Re: Status of Improvement Permit Application #5-5-11319

On February 21, 2005, an Environmental Health Specialist from the Harnett County Health Department attempted to evaluate your property for the purpose of issuing an Improvement Permit. This individual was unable to evaluate your property for one or more of the following reasons.

Lot 79 Woodshire

Revised
SITE PLAN APPROVAL
DISTRICT RAZOR USE SPD
#BEDROOMS 4
4/8/05 PRR
Date Zoning Administrator

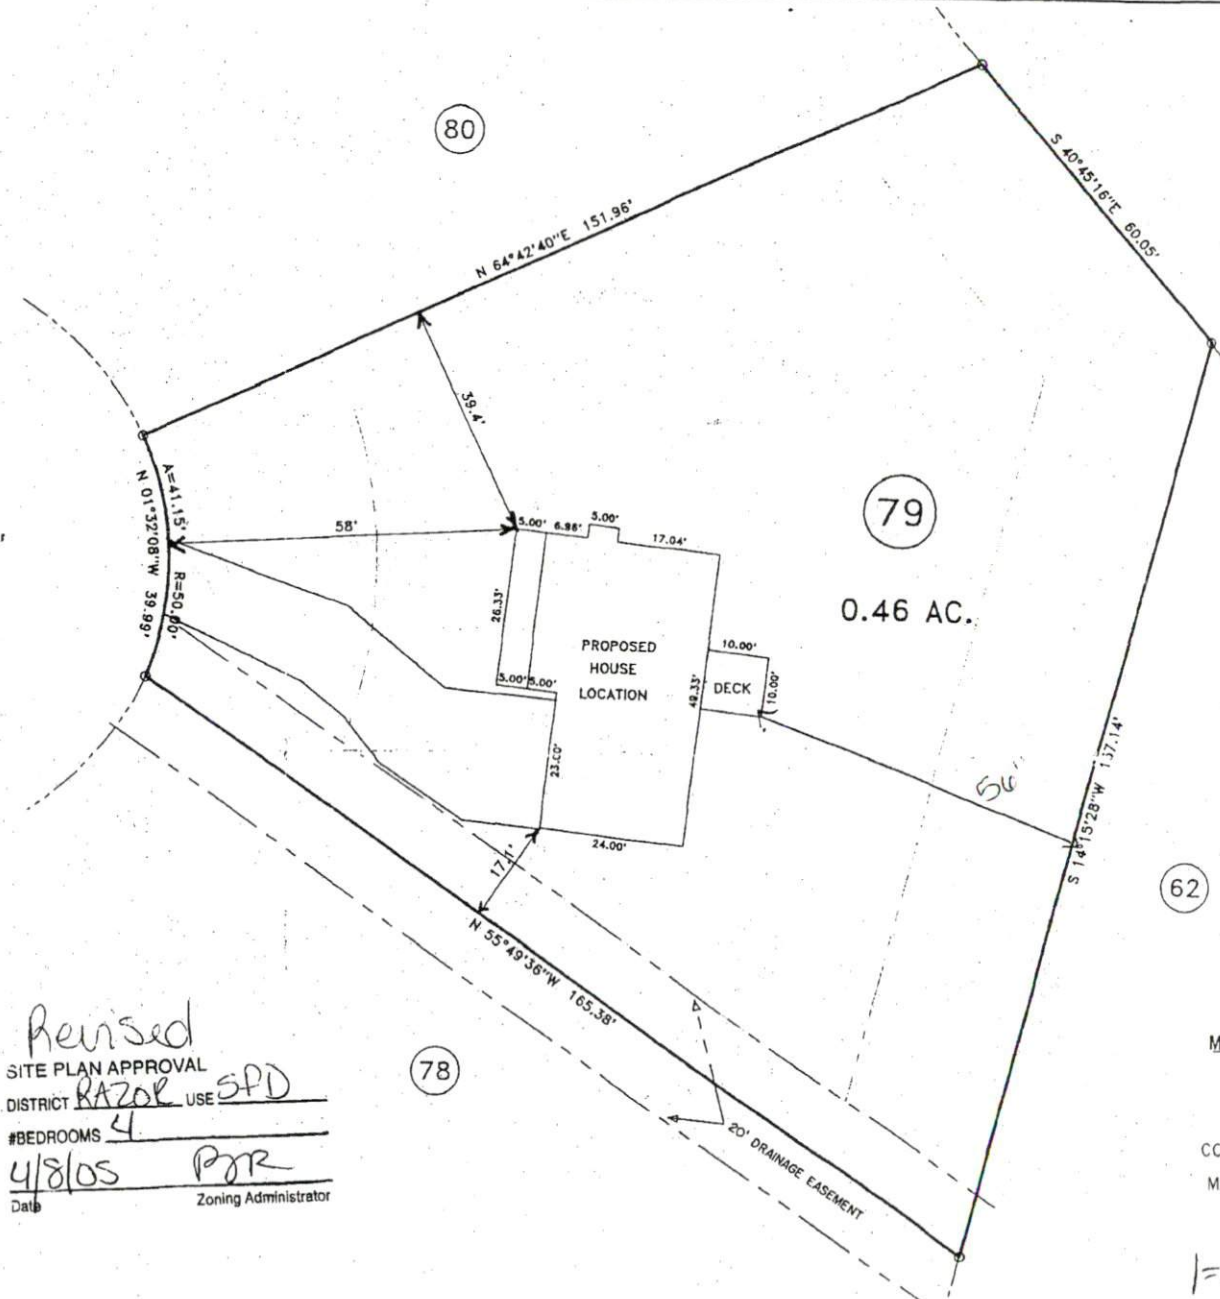
House must be moved
Back out of Area of
Good Soils Drive to
house must be along
lot 79/78 Property Line

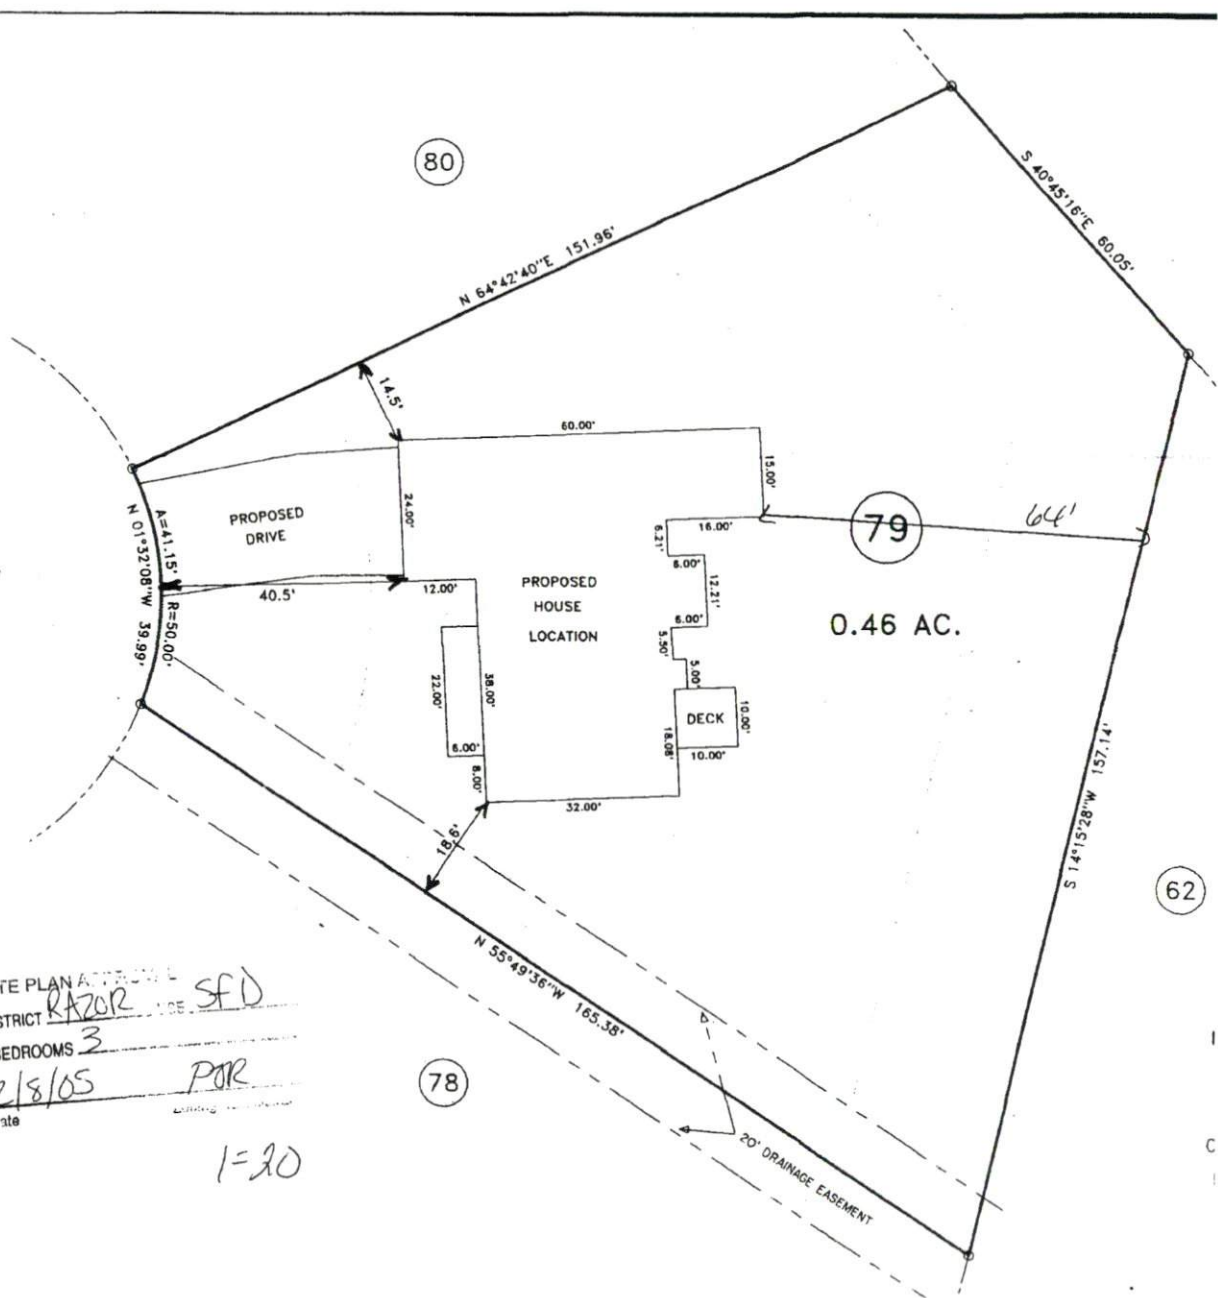
- 1. Property lines/corners not marked or labeled
- 2. House corners not marked or labeled
- 3. Directions not clear to property
- 4. Property needs brush or vegetation removed
- 5. Backhoe pits required
- 6. Other House must be moved back out of area of good soils as shown on the attached map.
